Ribble Valley Borough Council

DELEGATED ITEM FILE REPORT - REFUSAL

Application No:	3/2015/0517/P (PA)
Development Proposed:	Single storey extension to rear and extension of curtilage to create a walled back garden at Wolfen Hall, Fish House Lane, Chipping

4343-01

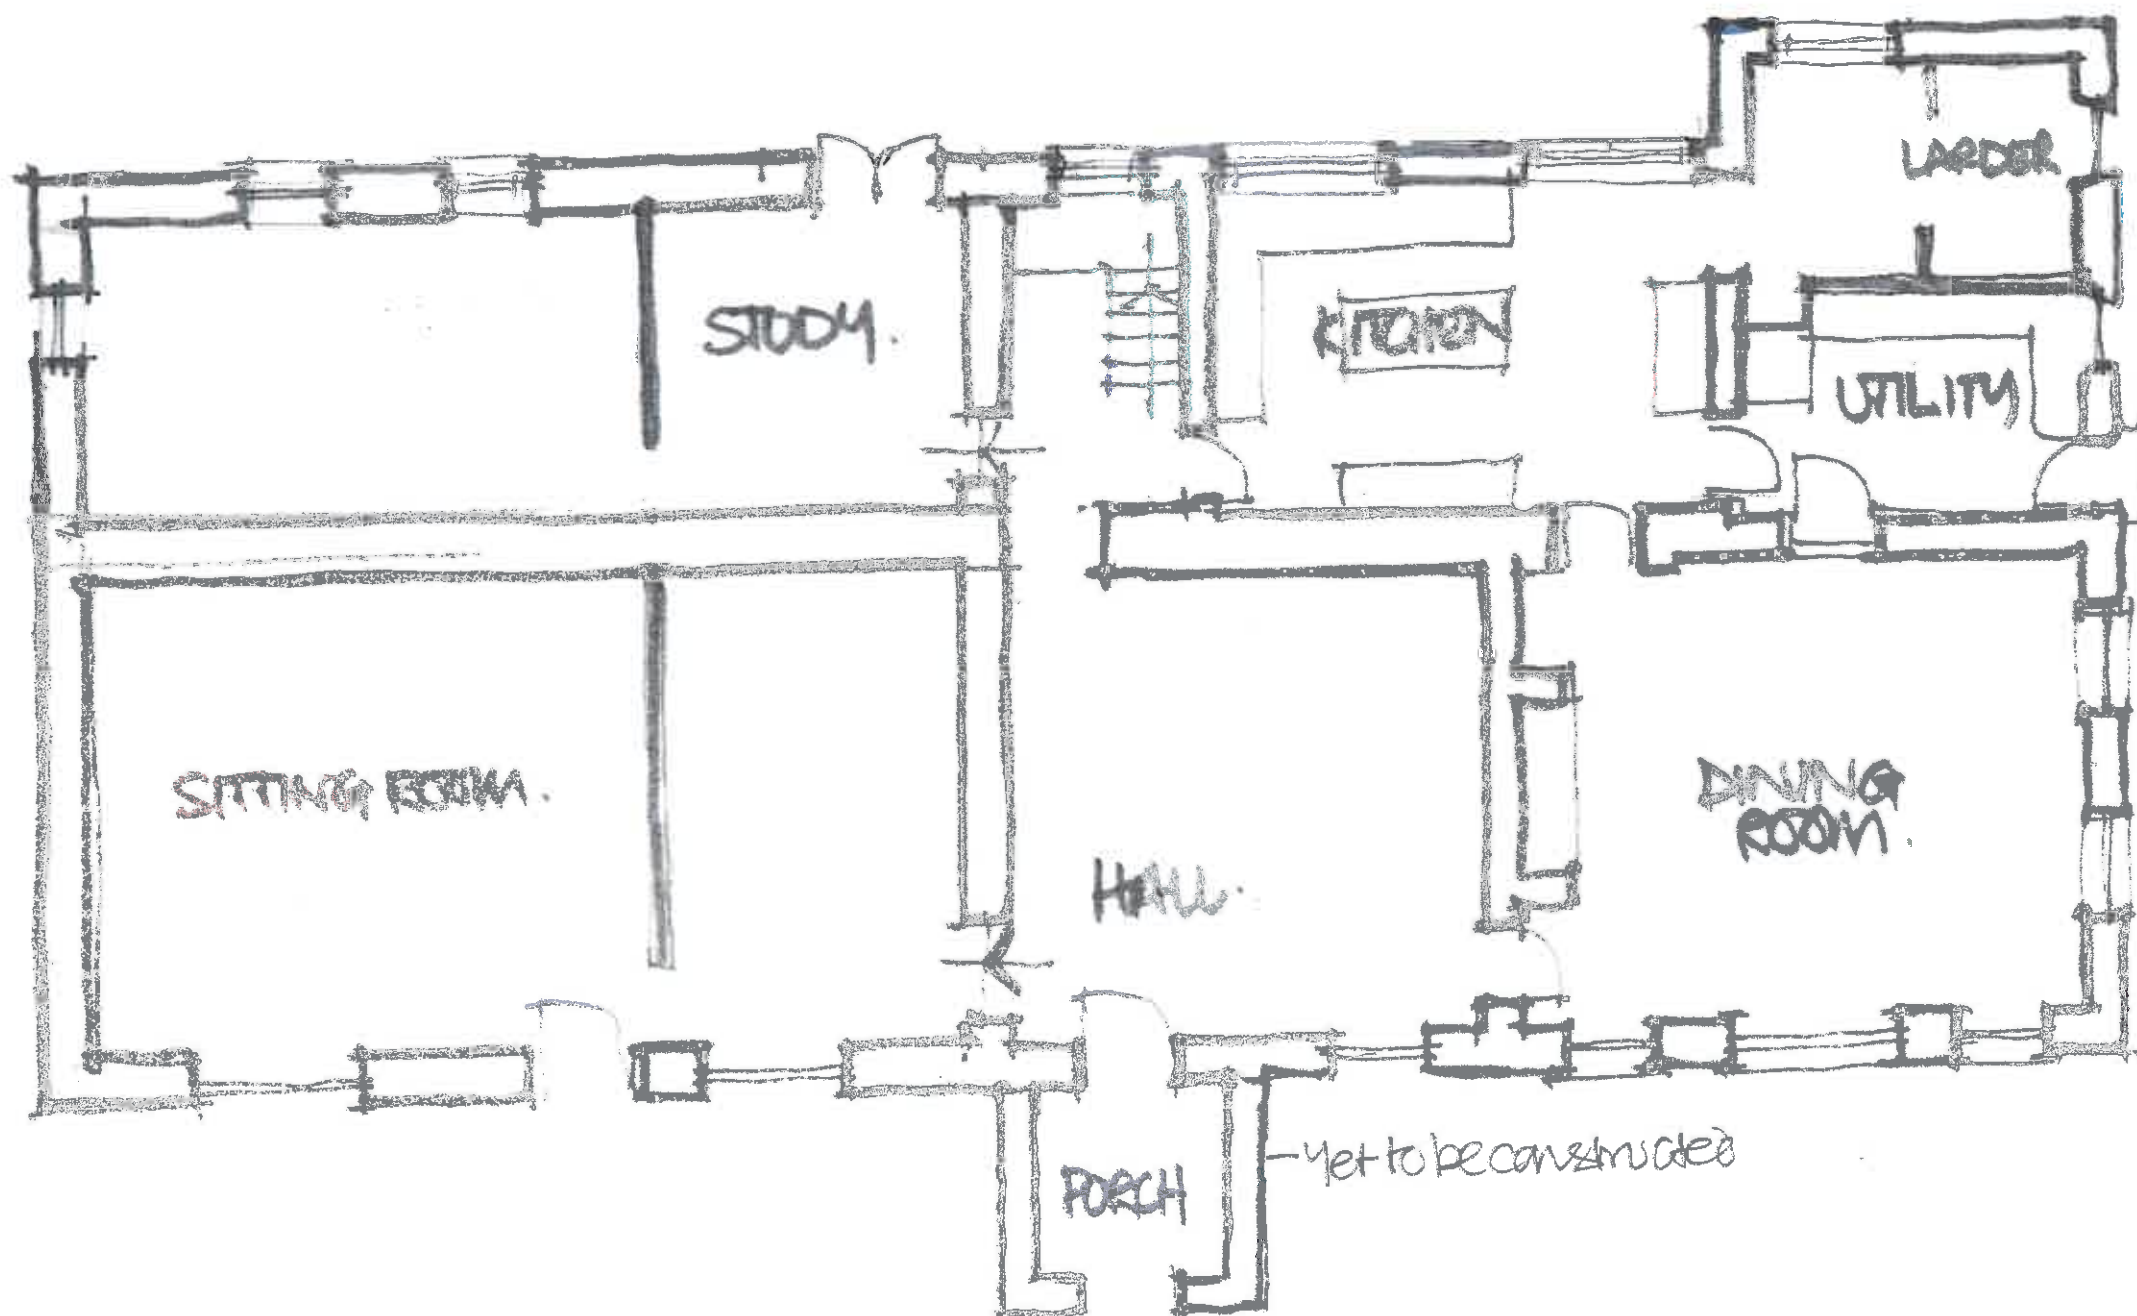
The submitted site plan only includes part of the listed building within the ‘red line’.

Drawing Title
**PROPOSED GROUND
 FLOOR PLAN**

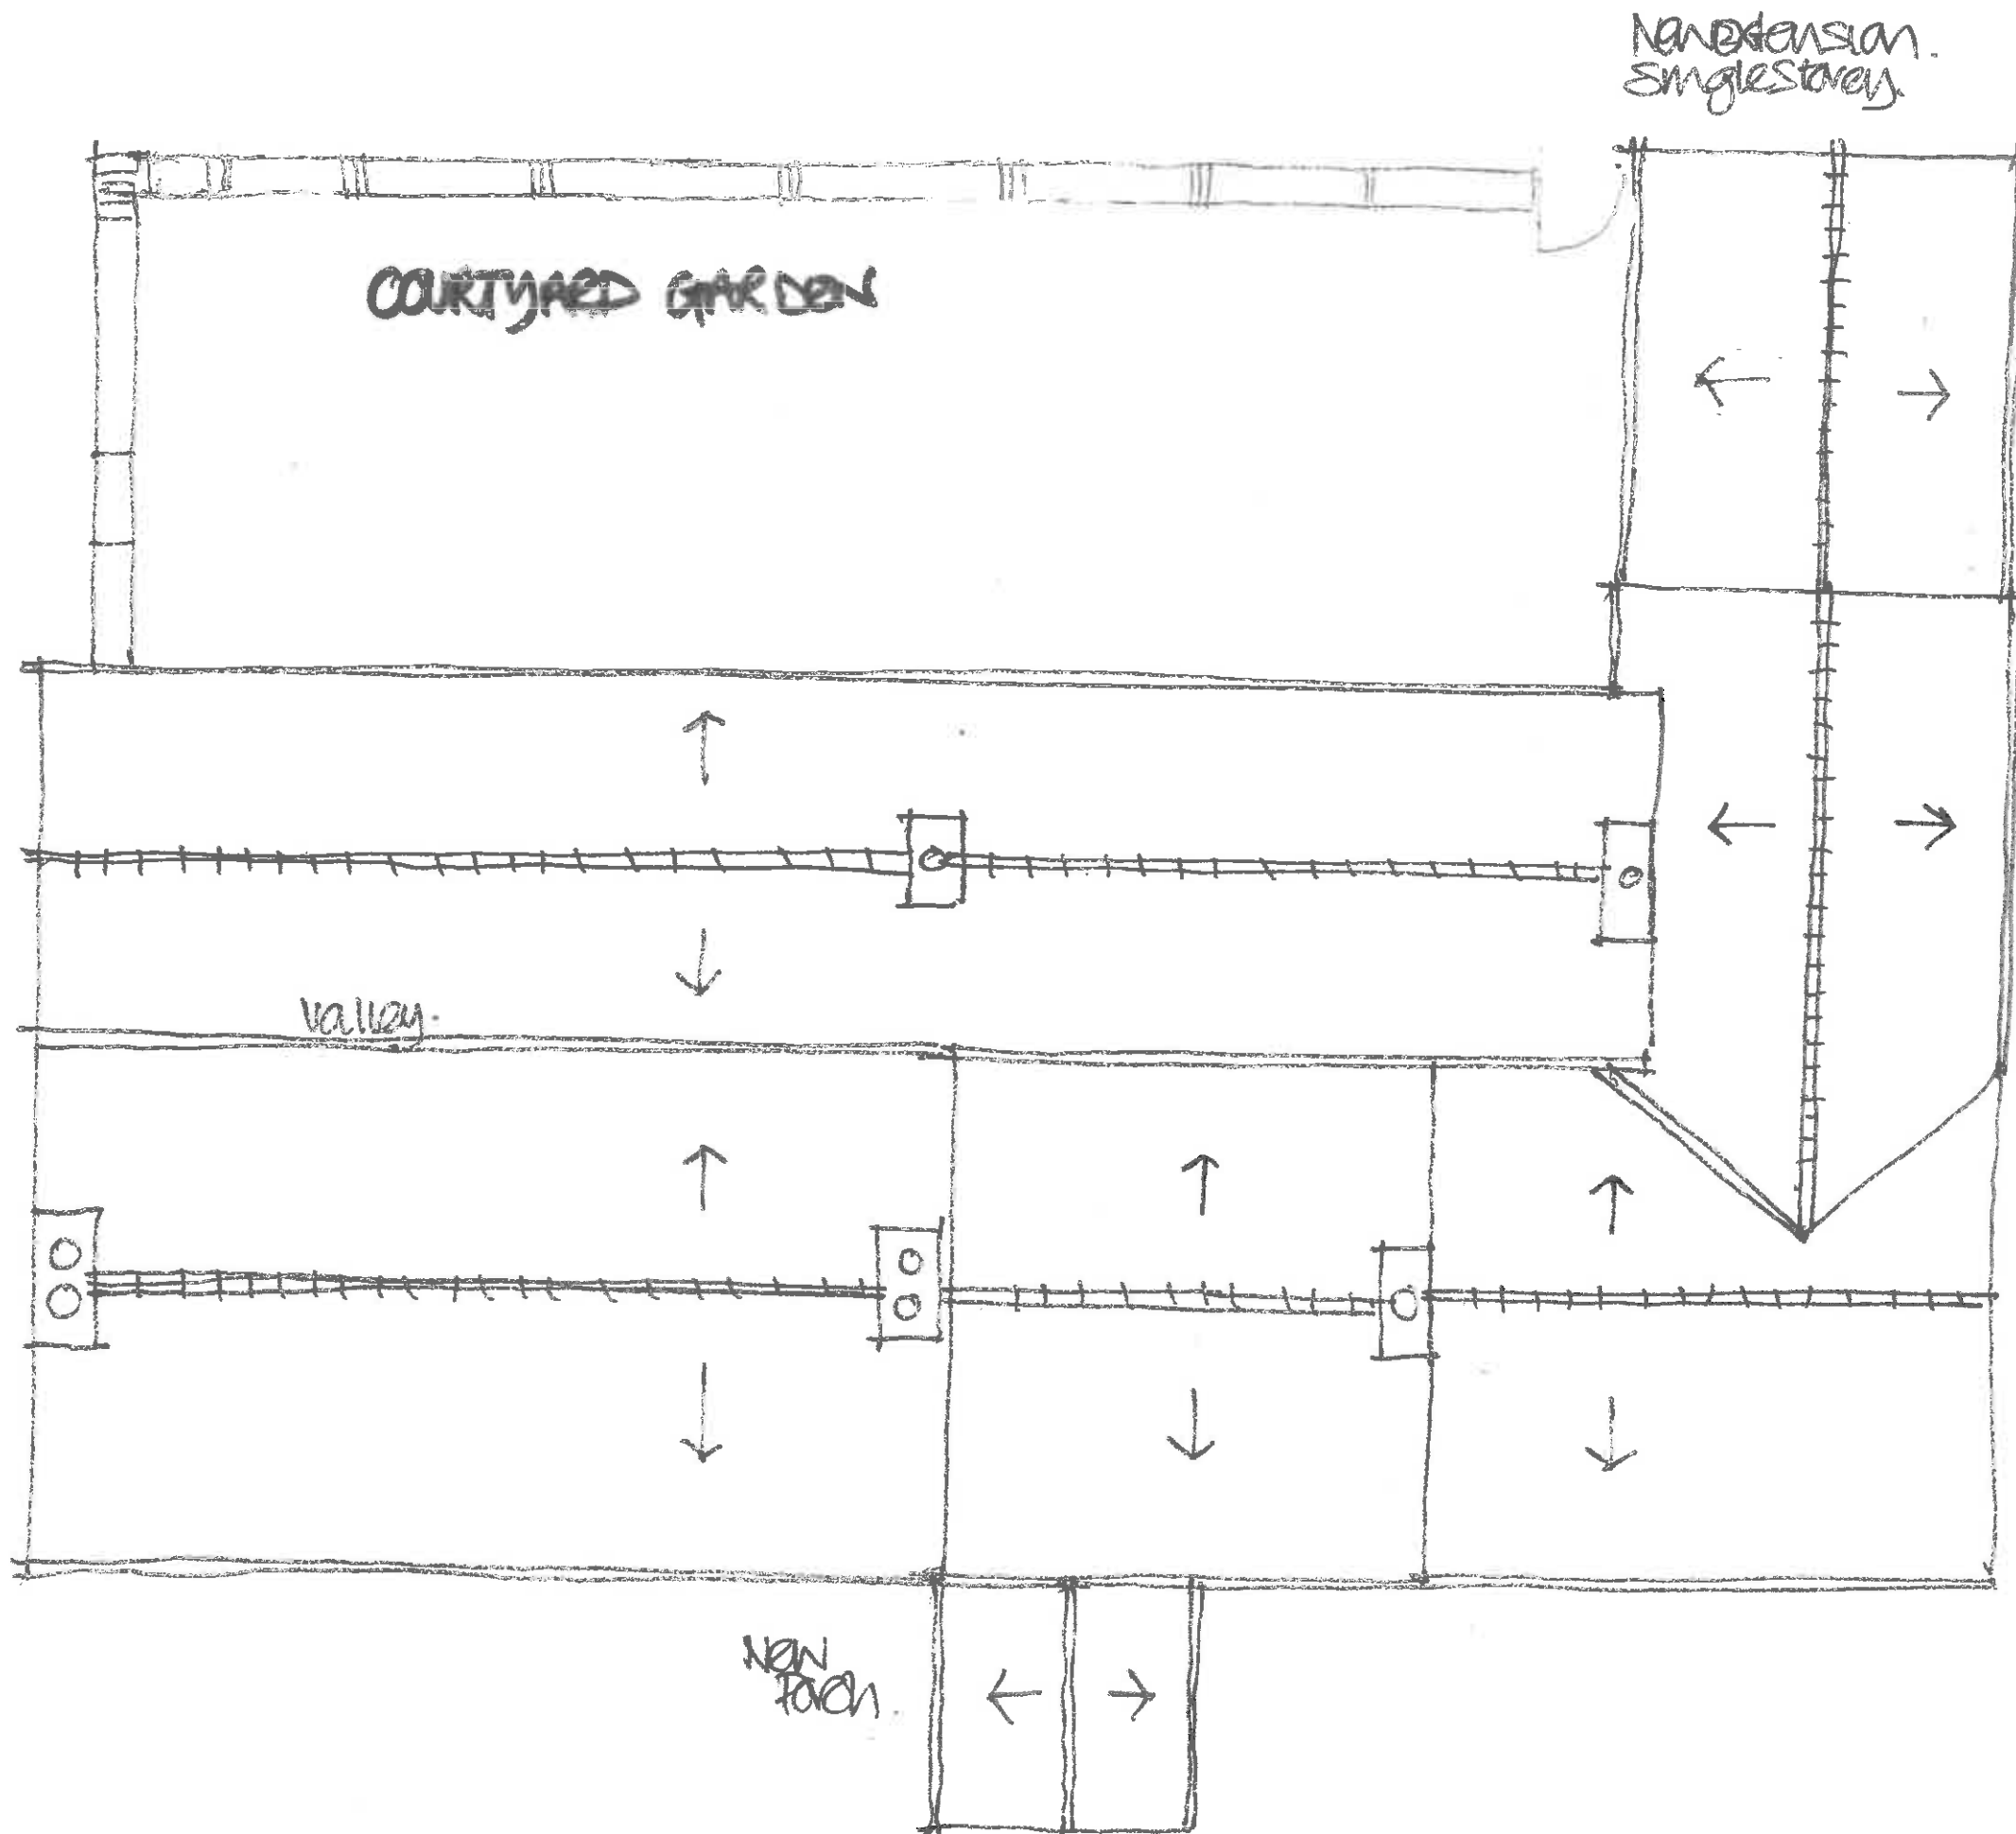
The proposed floor plan identifies “Replace window with new doors” but this is not illustrated on the elevation plan.

PROPOSED REAR (NORTH ELEVATION)

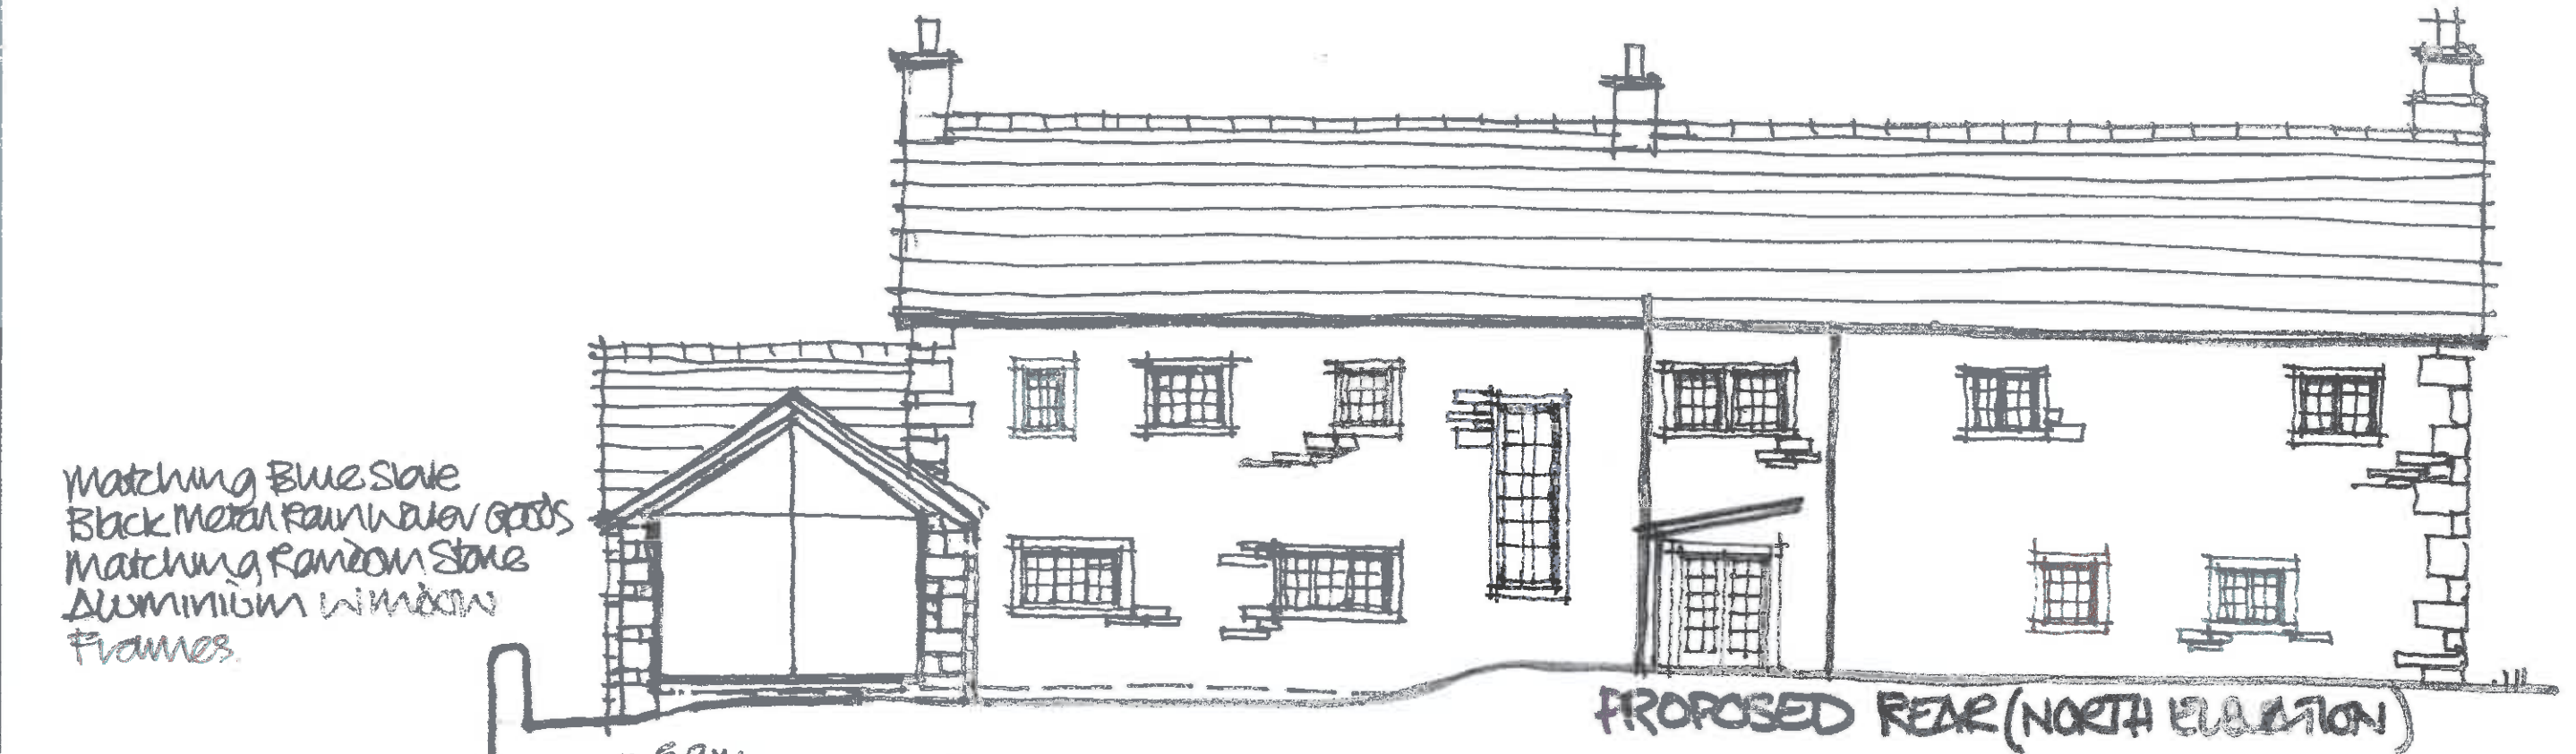
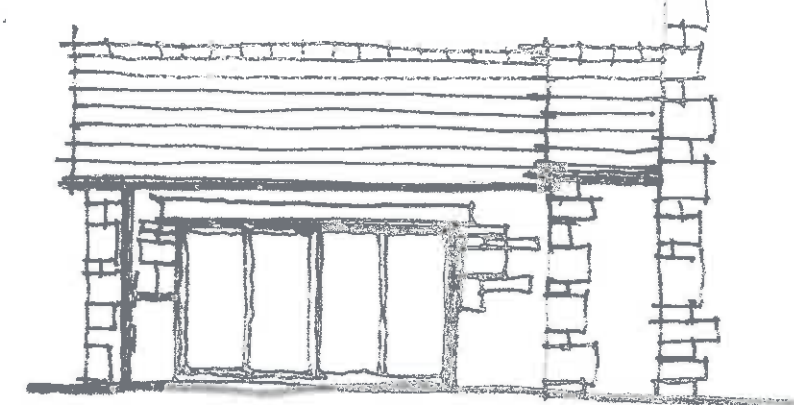
In my opinion, the proposed extension, patio door creation and enclosure of land to the rear within a 1.8m high wall will be harmful to the special architectural and historic interest and significance of the listed building and the character of the Forest of Bowland AONB.
